Submissions Report

Mixed-Use Development with In-Fill Affordable Housing

2-6 Pilgrim Avenue and 11-13 Albert Road, Strathfield

SSD-80432461

SECTION A-A

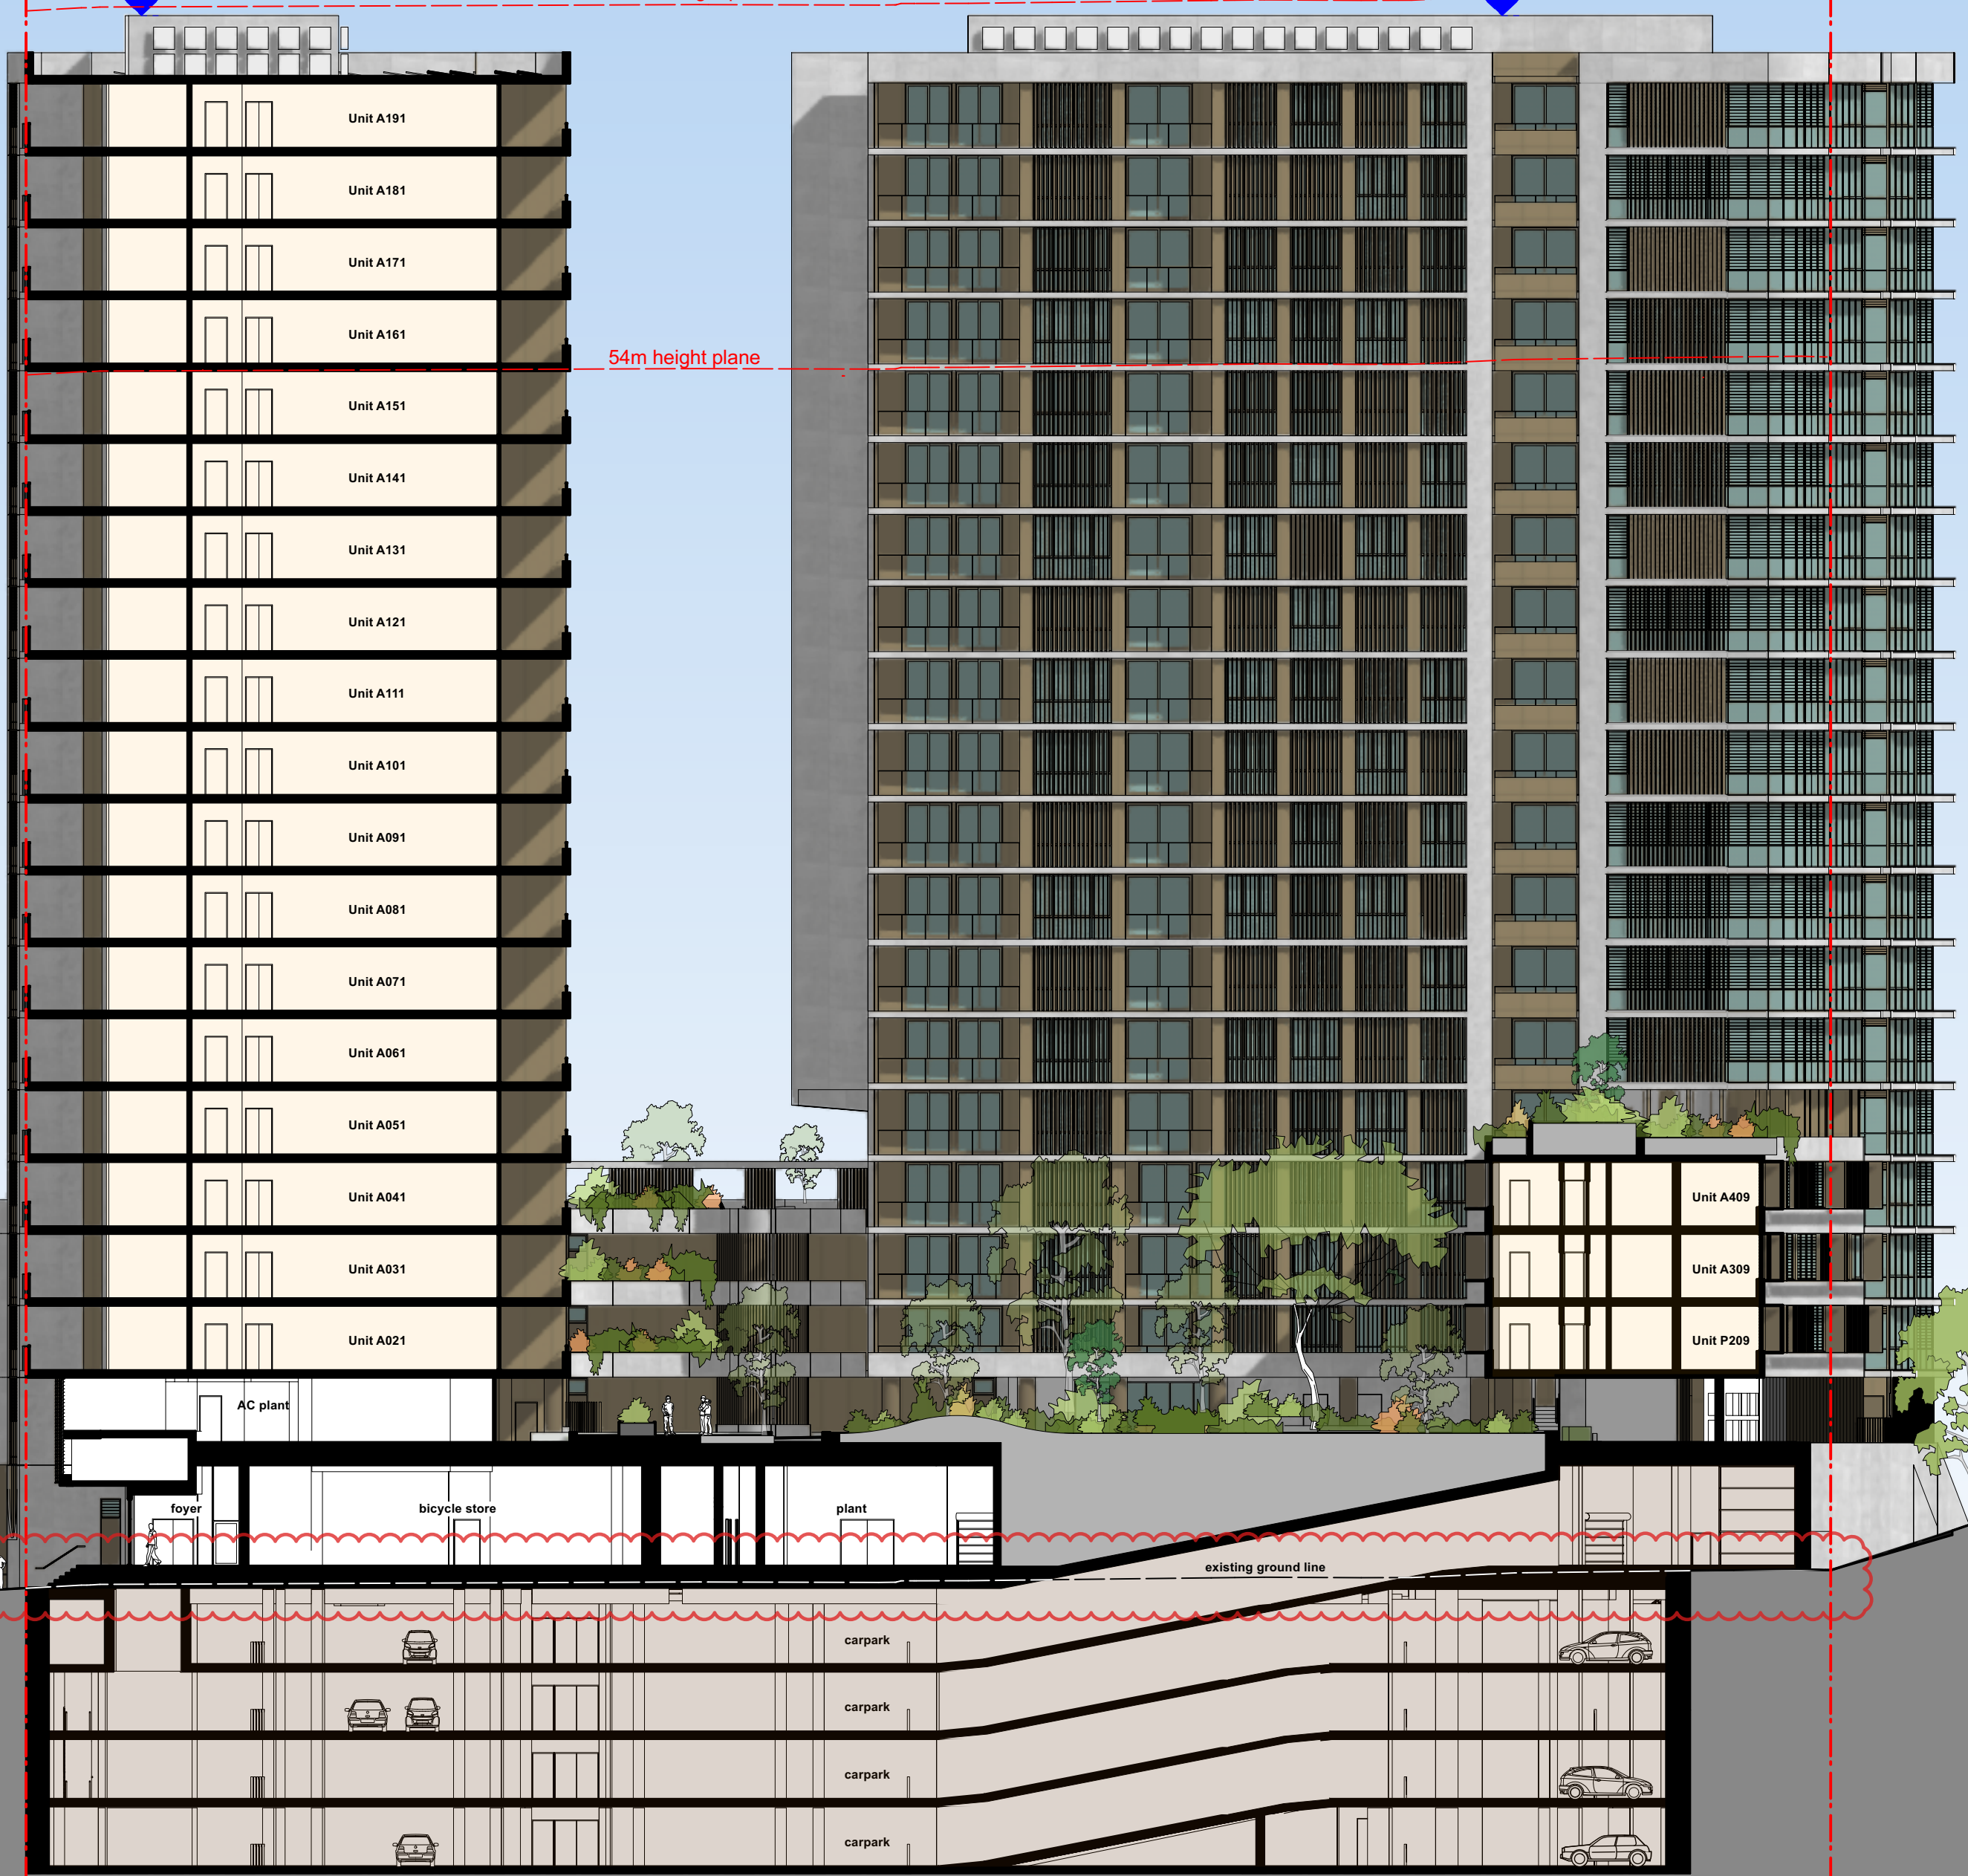
Matter Raised	Applicant Response
(b) Annotate on the Section and Elevation Plans the maximum height line of 70.2m and show the existing ground level to confirm the proposed building heights.	assessed in the EIS. In particular, it is noted that the GFA increase relates solely to the ground floor back of house areas and does not change the massing or form of the building in any way. The updated Architectural Drawings (Appendix B) include revised Section and Elevation Plans that depict the existing ground line and proposed maximum building height.

SOFT LANDSCAPE AREA - LEVEL 04
256m² soft landscaping on structures

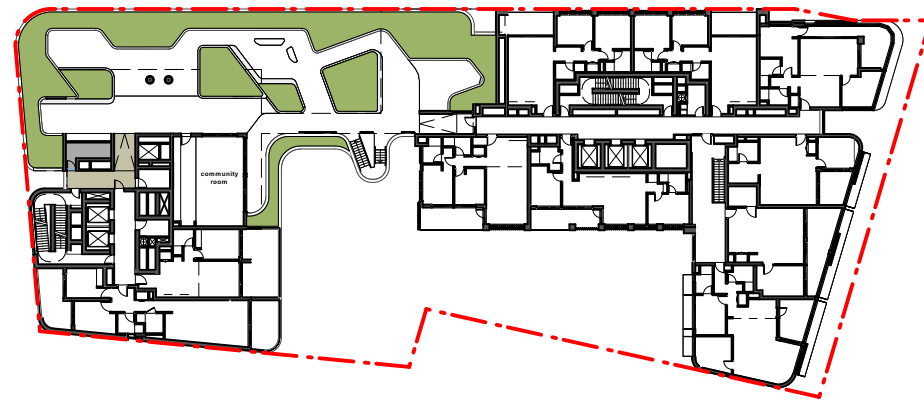
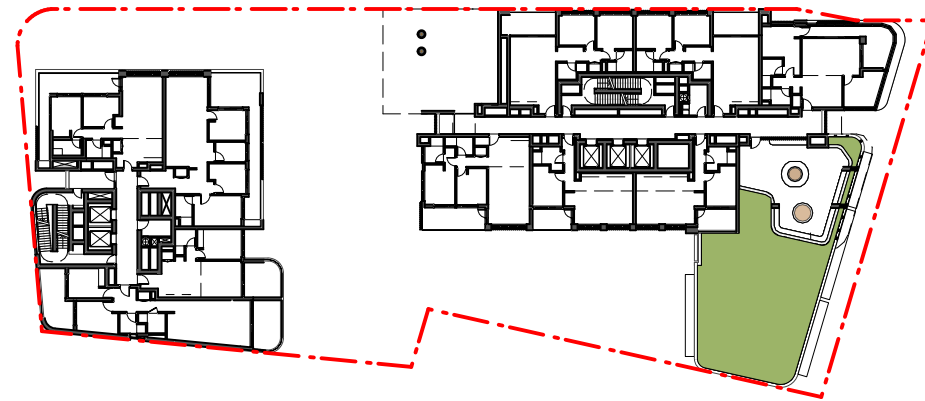
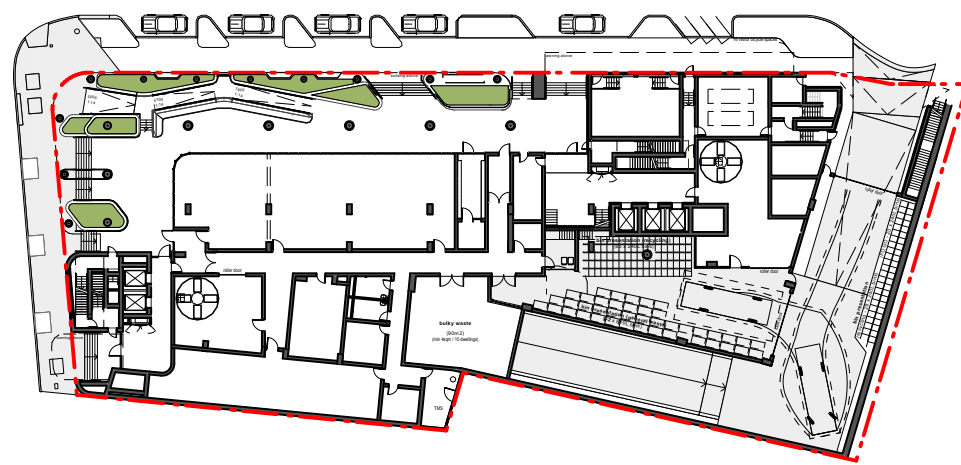
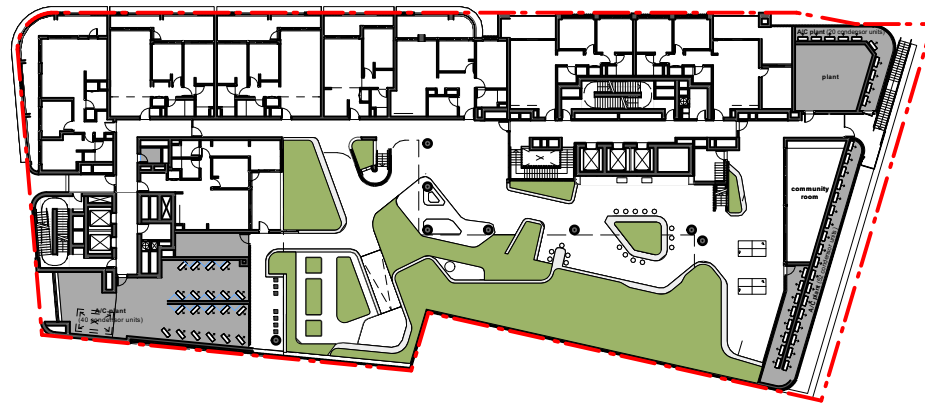
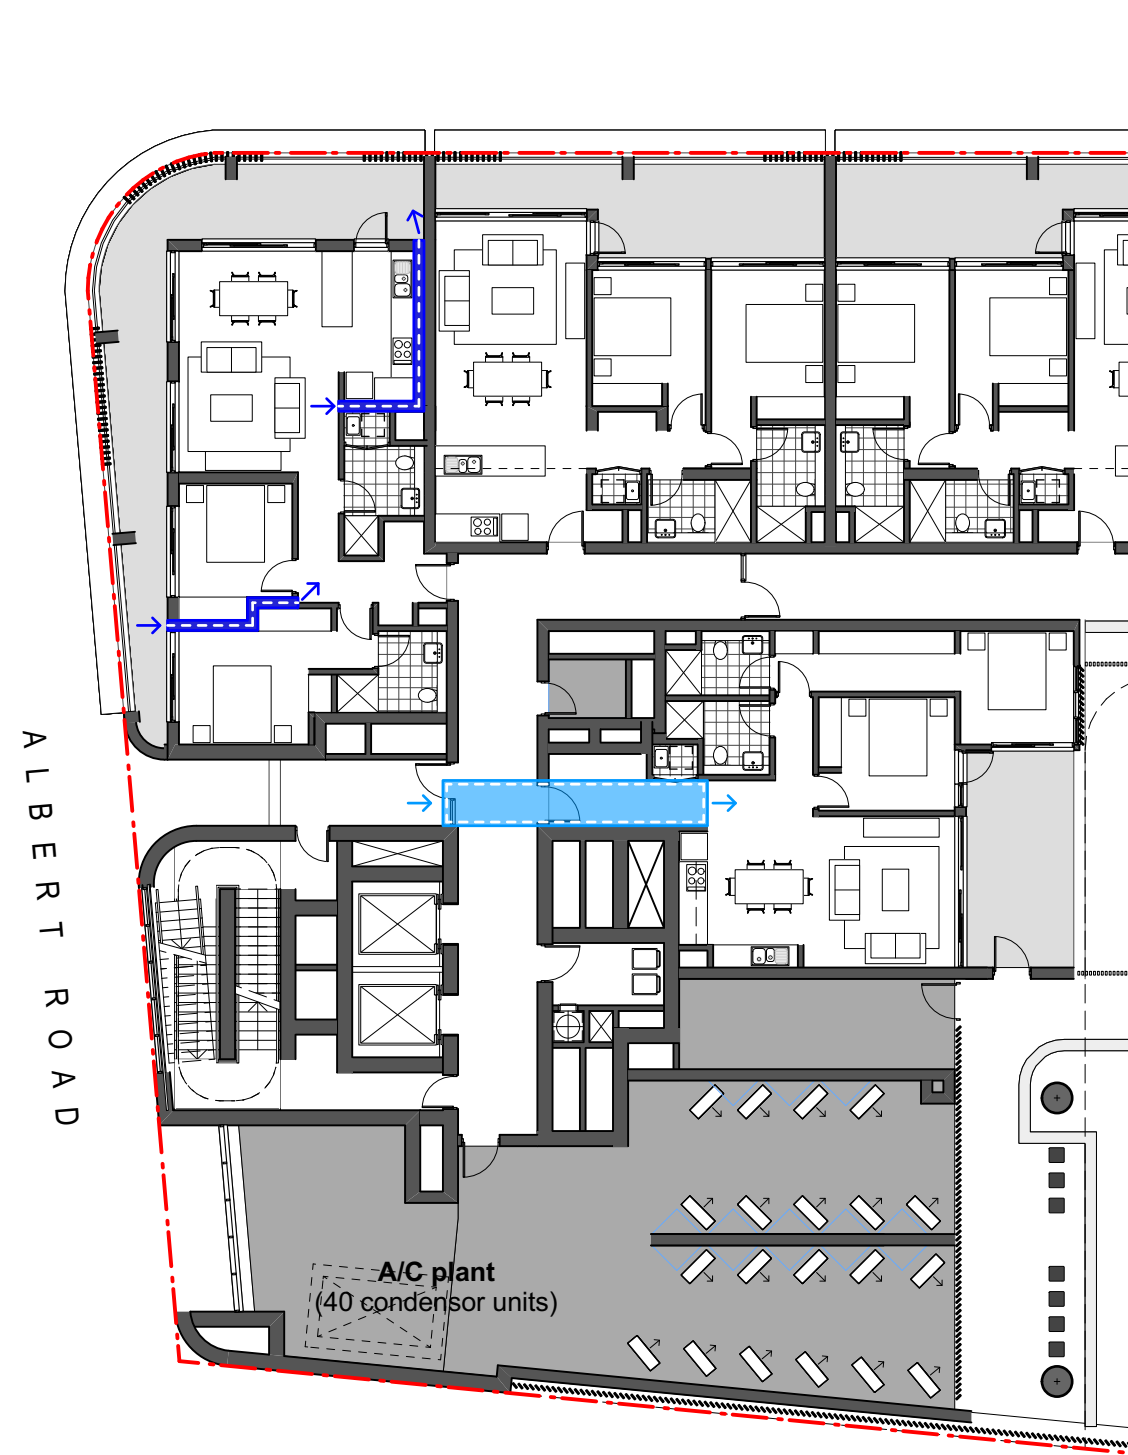
<i>(b) Confirm the area of proposed soft landscaping proposed across the site and investigate opportunities for deep soil.</i>	Although, as noted above, the public verge on Pilgrim Avenue is owned by the applicant and is provided with significant deep soil planting and tree planting, this area is not included in the landscaped area calculations and the project, like most projects of this scale, is based on boundary-to-boundary excavation to limit the number of basements and depth of excavation. To compensate, the project: - Proposes 1,619m² of landscaped area (communal open space), equivalent to 56% of the site area, over three (3) levels; - Populates those spaces with a series of planters which: - Occupy 815m² / 50% of that space; - Range in depth from 1m to over 3m; - Provide over 880m² of soft landscaping which is greater than 30% of the Site; and - Support significant planting including over 30 canopy trees within the Site.
